Recommendation Report for Planning Permission for Works or Extension to a Dwelling

REF NO: R/106/21/HH

LOCATION: 26 Tennyson Avenue
Rustington
BN16 2PH

PROPOSAL: Erection of single storey rear extension and hip to gable loft conversion with 1 x side dormer

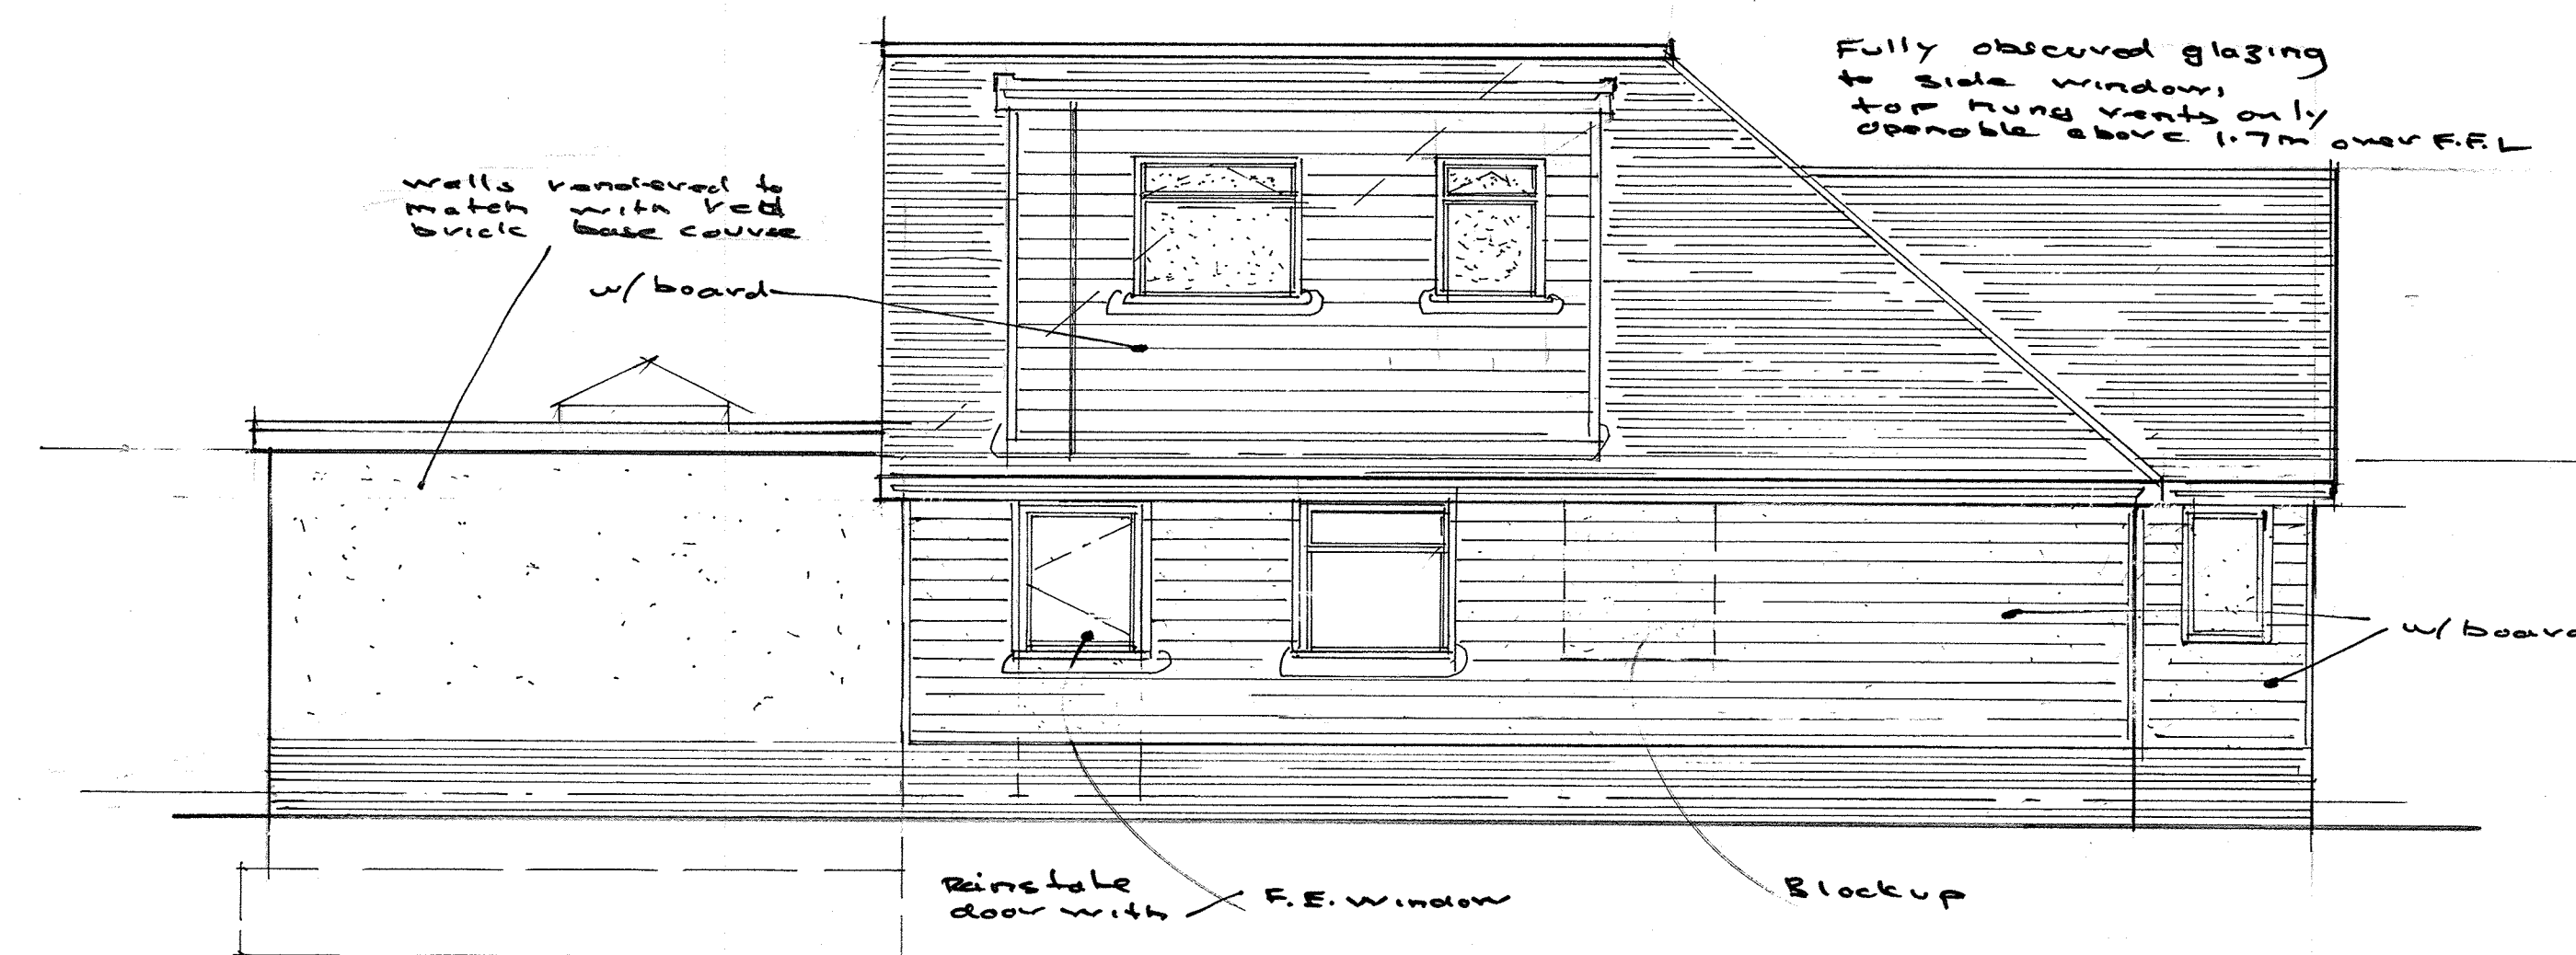
The ridge height and eaves heights on the main pitched roof are to be maintained at their existing levels. The eaves to the flat roof extension are to be minimally higher, this is not seen as a reason to refuse the application though. The overall scheme increases the habitable space within the building and the loft conversion is seen as an effective use of the land.

It is proposed to finish the extension with render, currently found on site and composite weatherboard cladding, which is being introduced as a new material. It is noted that both the new dormer and existing front elevation will be clad in weatherboard, so the old and new will be in-keeping with each other.

The proposed dormer is located on a side elevation, although this is not ideal it is noted that it will be adjacent to the flank wall and roof to the property to the south. Therefore, its bulk will not overbear any of the neighbouring properties amenity space. Additionally, it is formed within the existing footprint of the dwelling.

dwelling. There is to be a rear facing juliet balcony at first floor level. The side dormer is to be obscure glazed and have windows fixed shut below 1.7m. No new views will be created other than those already achievable.

- 3 The first floor windows to the south elevation hereby approved shall be non-opening below 1.7m above finished floor level and obscure glazed prior to the first use of the rooms. The windows shall be retained as obscure glazed/non-openable in perpetuity in the interests of protecting the privacy of neighbouring properties.
